**SITE DEVELOPMENT LETTER OF INTENT**

S-1

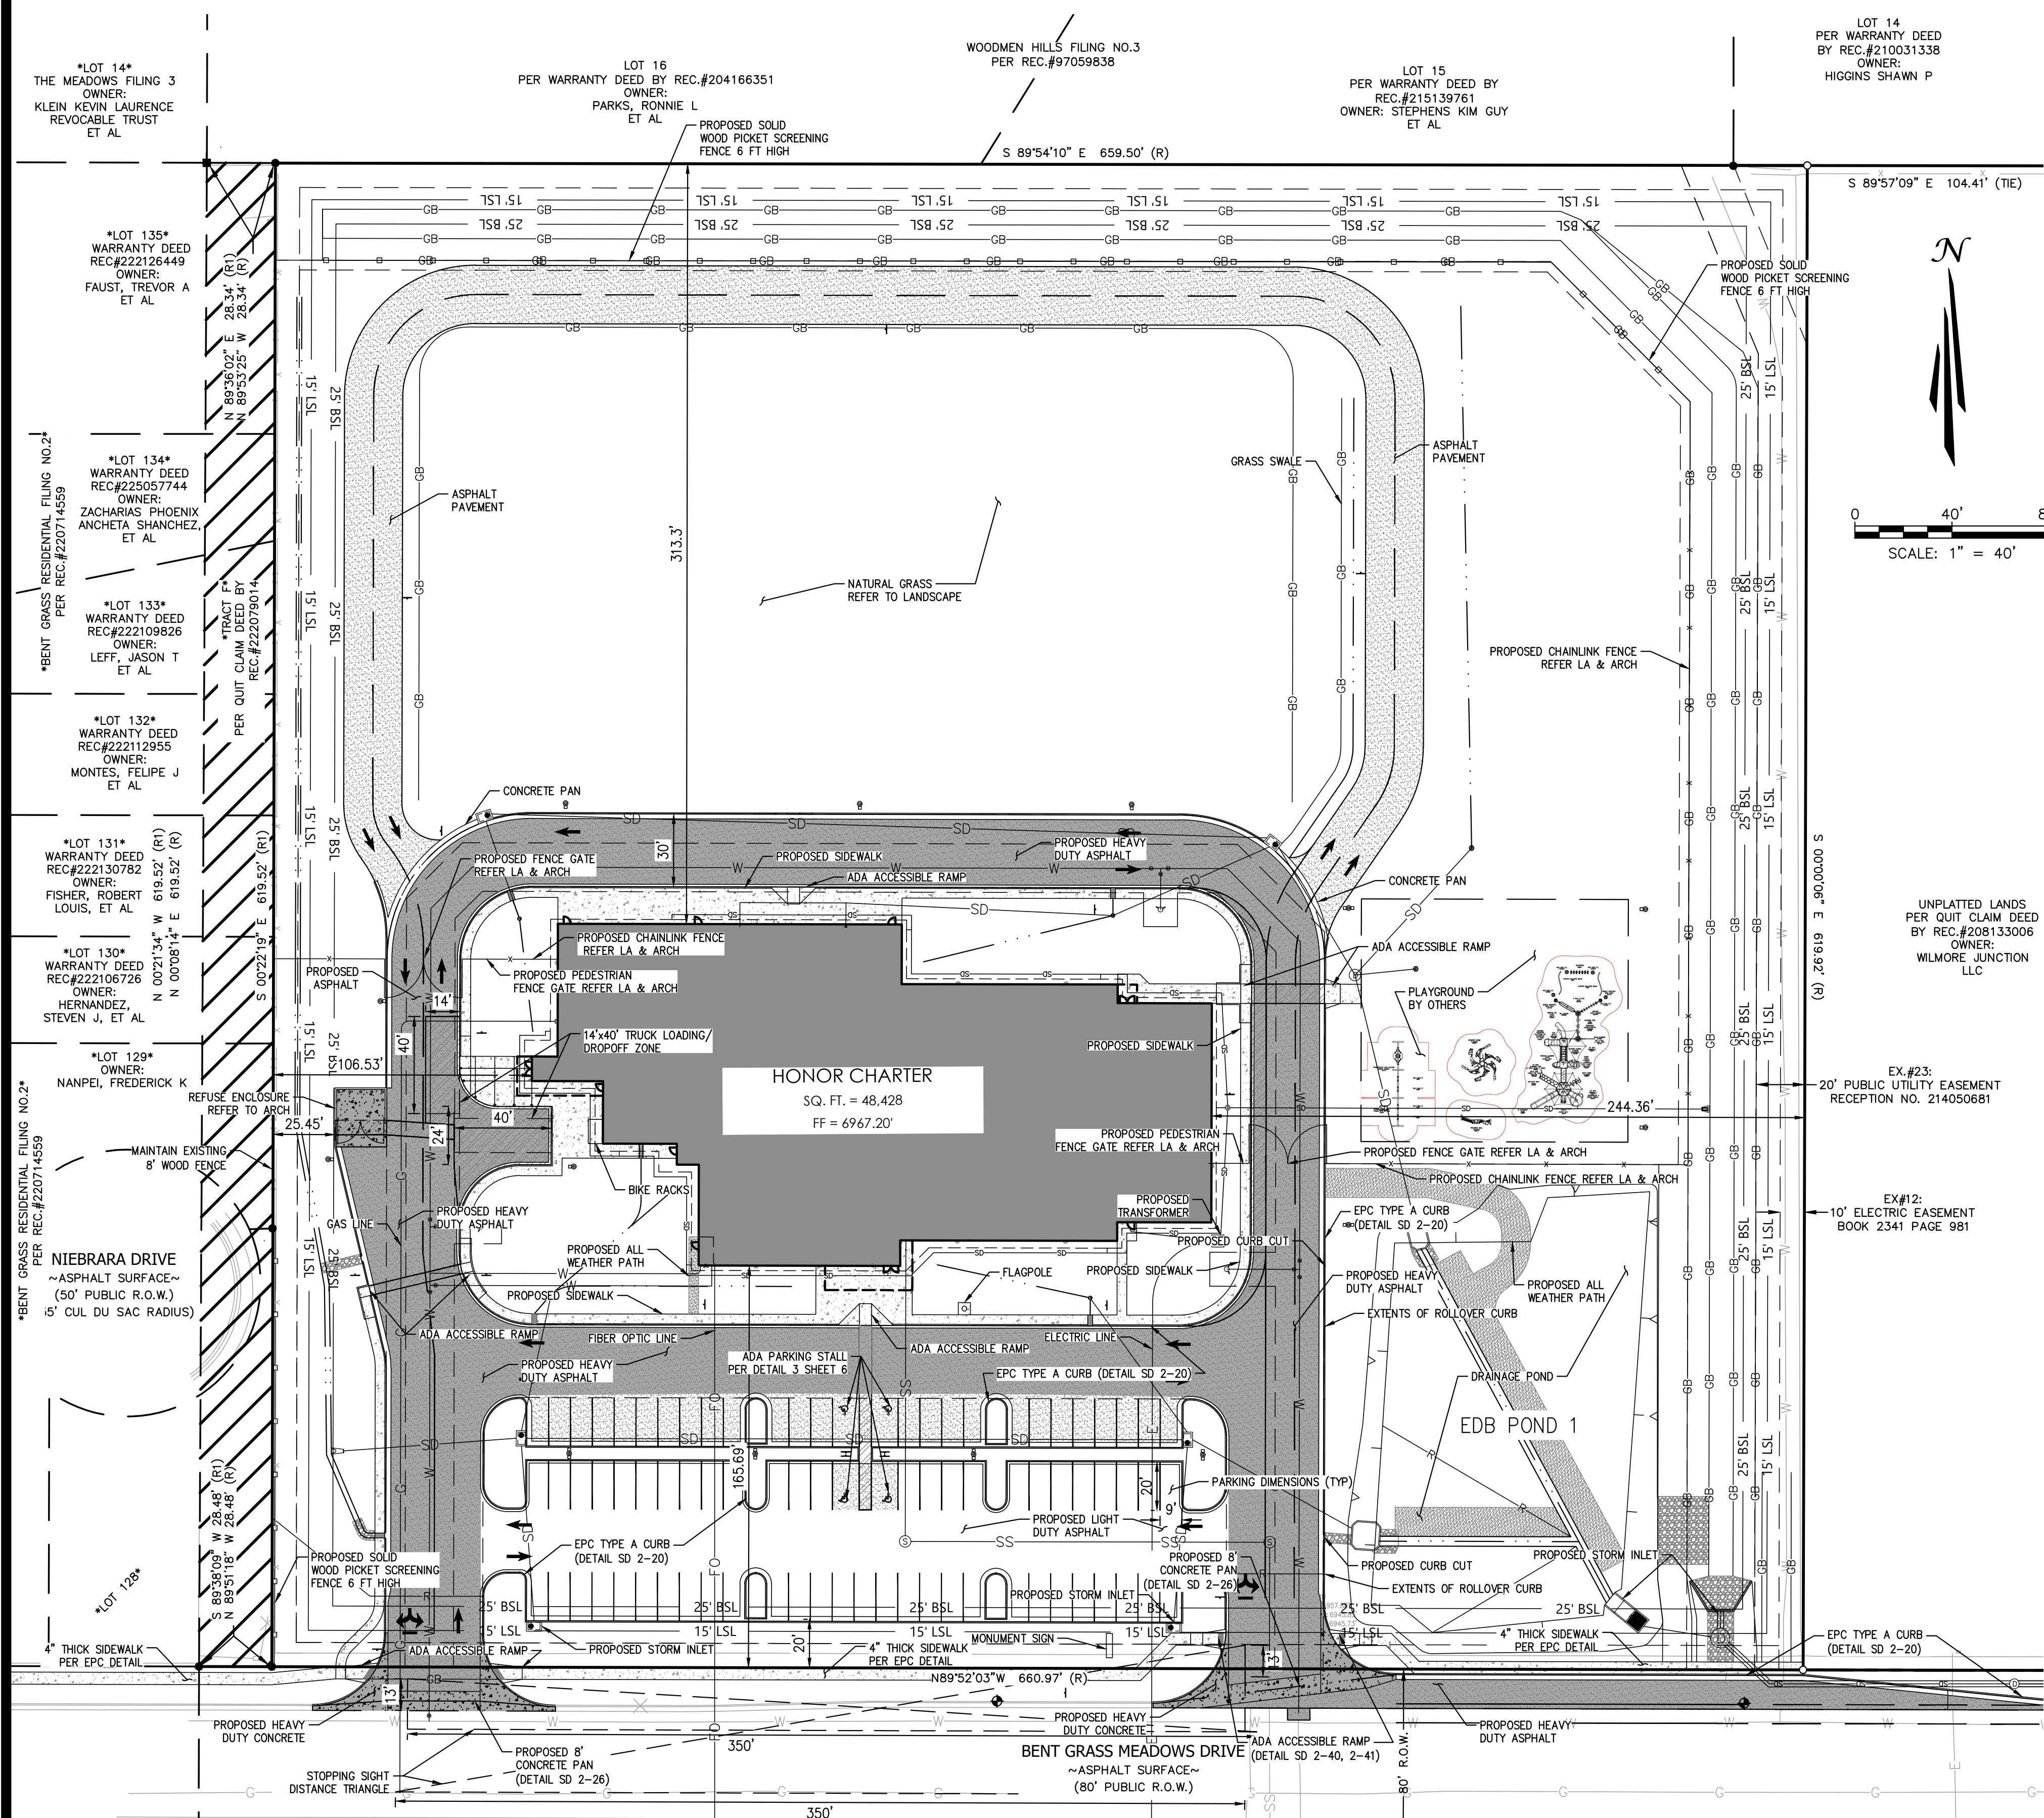
Please include a section for Road Impact Fees. Road Impact fees are charged by the following for the Woodmen Road Metro District: \$1.10/sf x 48,428sf = \$53,270.80
